Subject: DEVIATION REVIEW AND DECISION FORM

Subdivision or Project Name: McCune Ranch

Section of ECM from Which Deviation is Sought: Section 2.25.B.1 Spacing for Rural Minor Arterial
Specific Criteria from Which a Deviation is Sought: 0.25 mile spacing of proposed access (Road C) to Hodgen Road.
Hodgen Road is a classified as a Minor Arterial

Proposed Nature and Extent of Deviation: The standard is 0.25 mile (1,320') intersection spacing. The proposed
access (Road C) is spaced at approximately 780' (measured to center intersection).

HODGEN RD  
IMPROVEMENTS

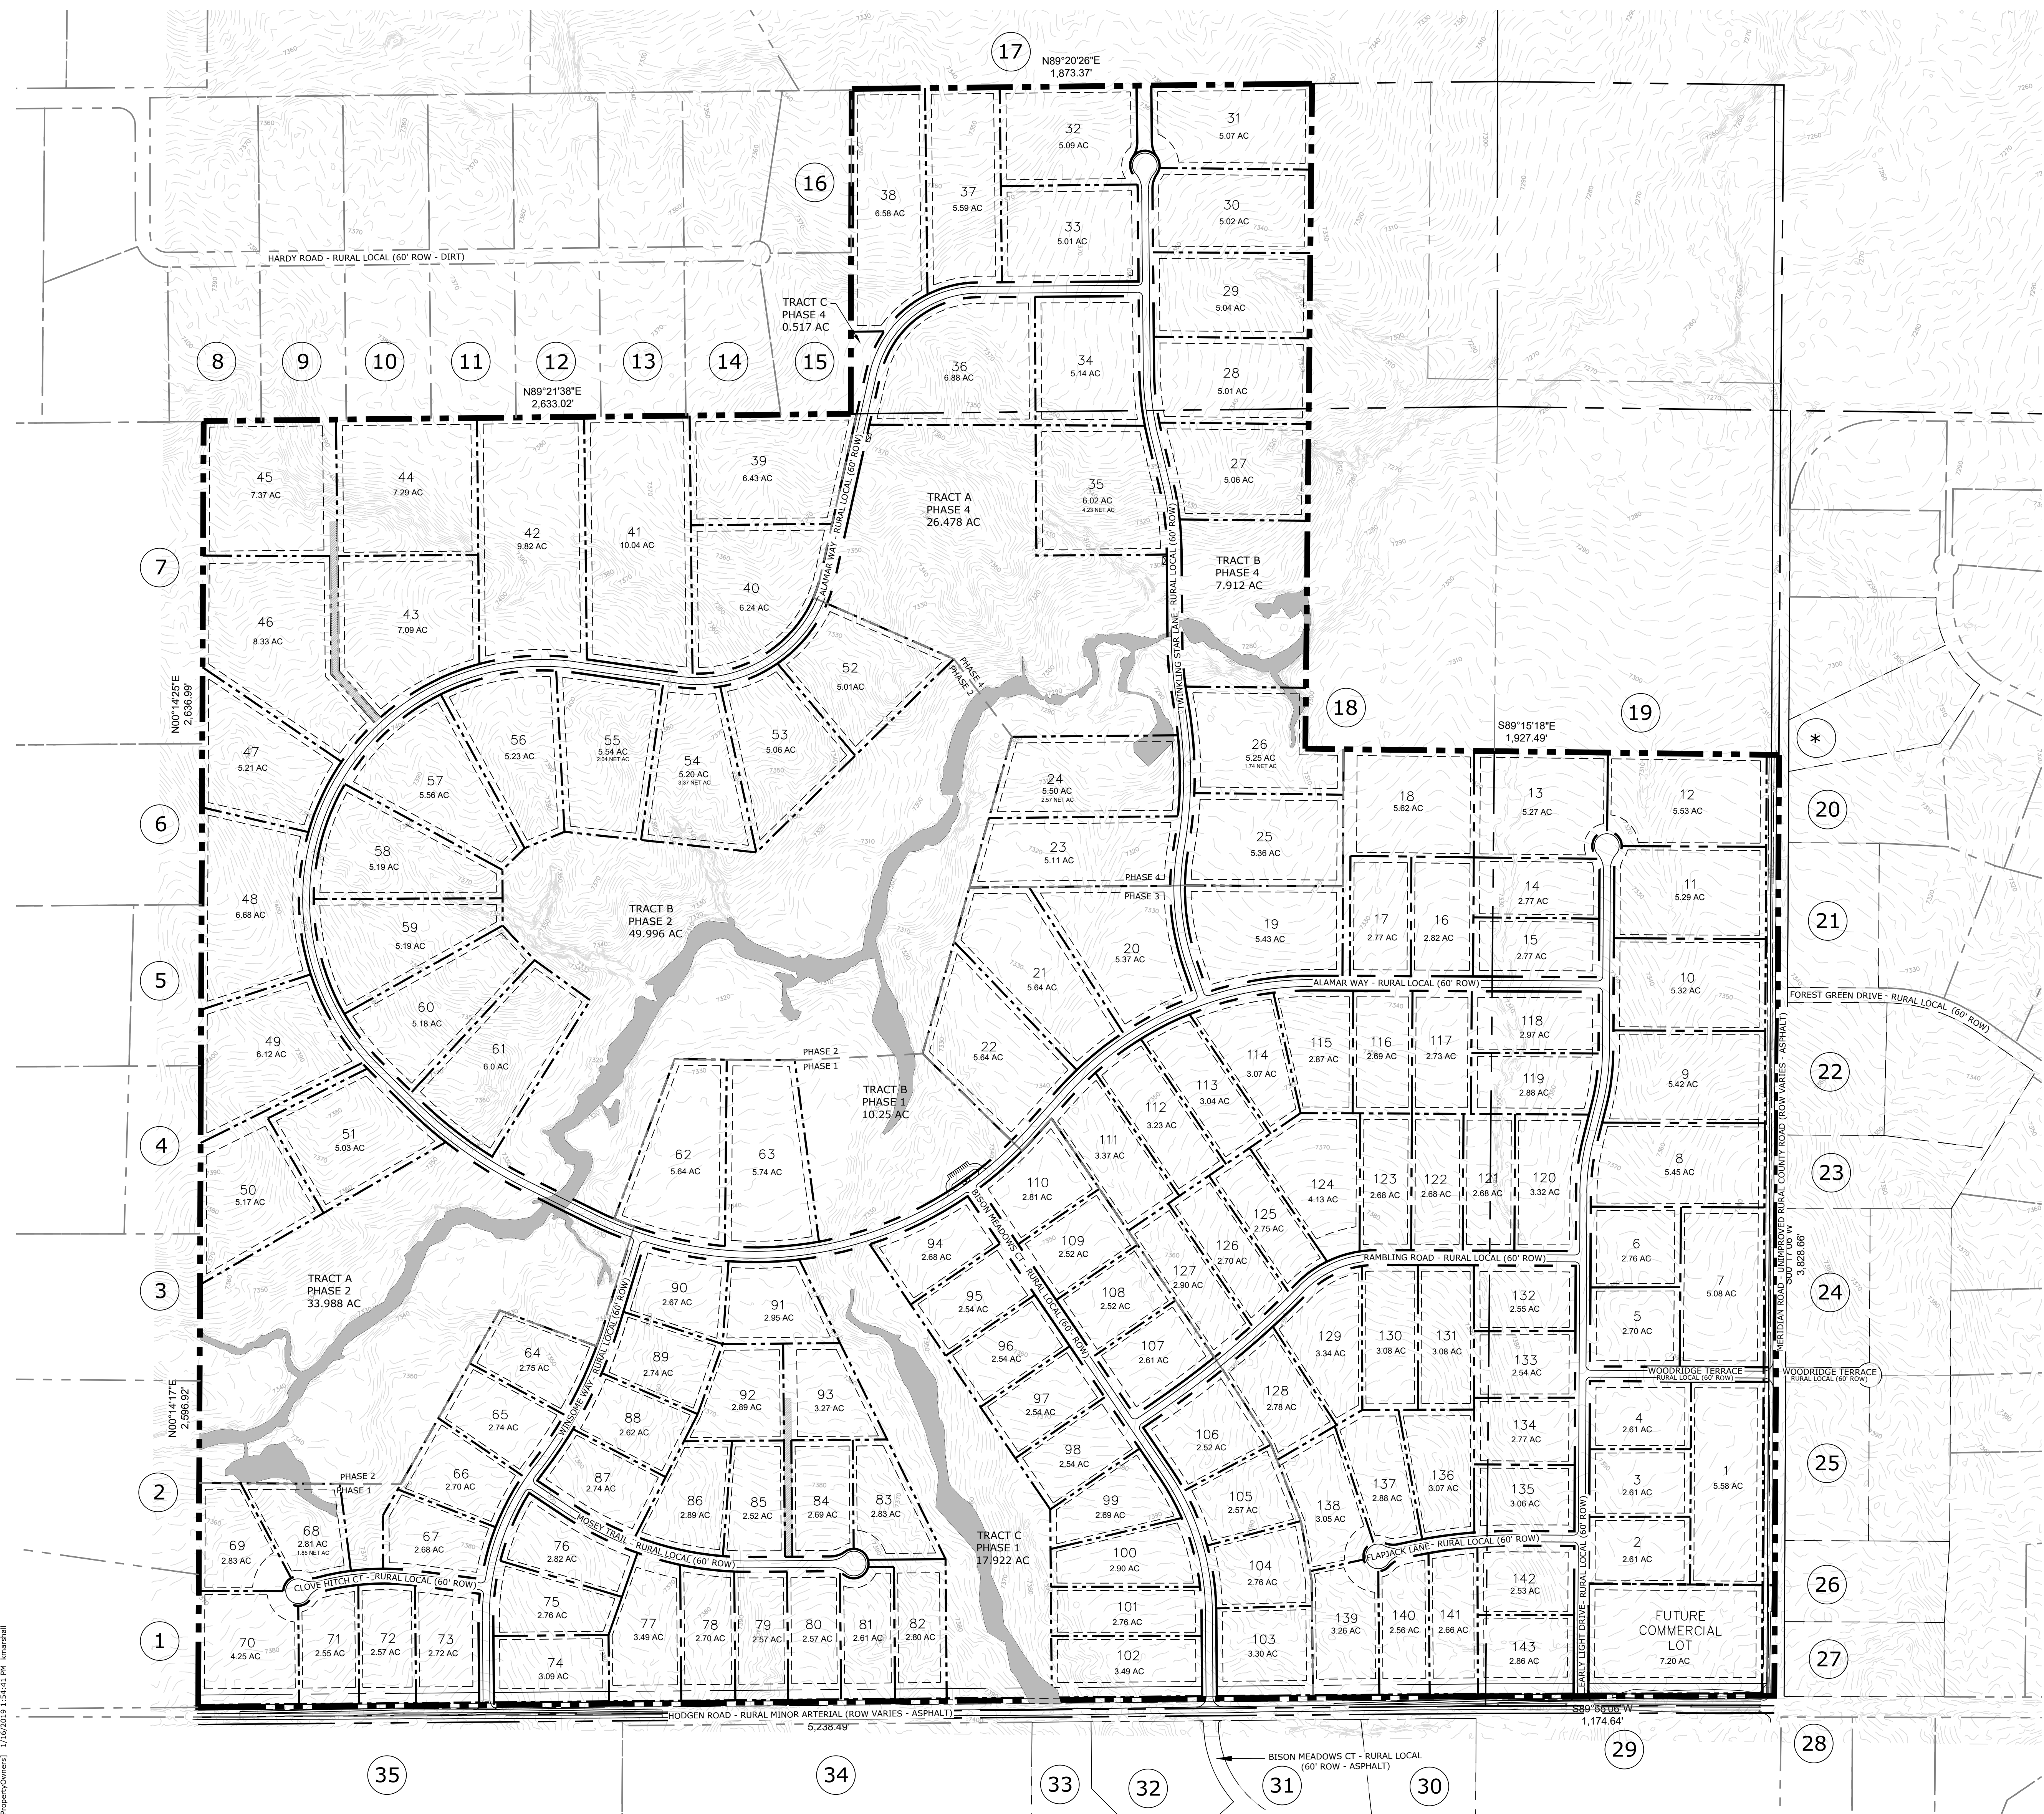
Provide a site exhibit with the following information:

1. Dimension label for the intersection spacing.
2. Length of the functional area for the western leg of the Meridian/Hodgden intersection.
3. Length of the functional area for the eastern leg of the Road C/Hodgden intersection.
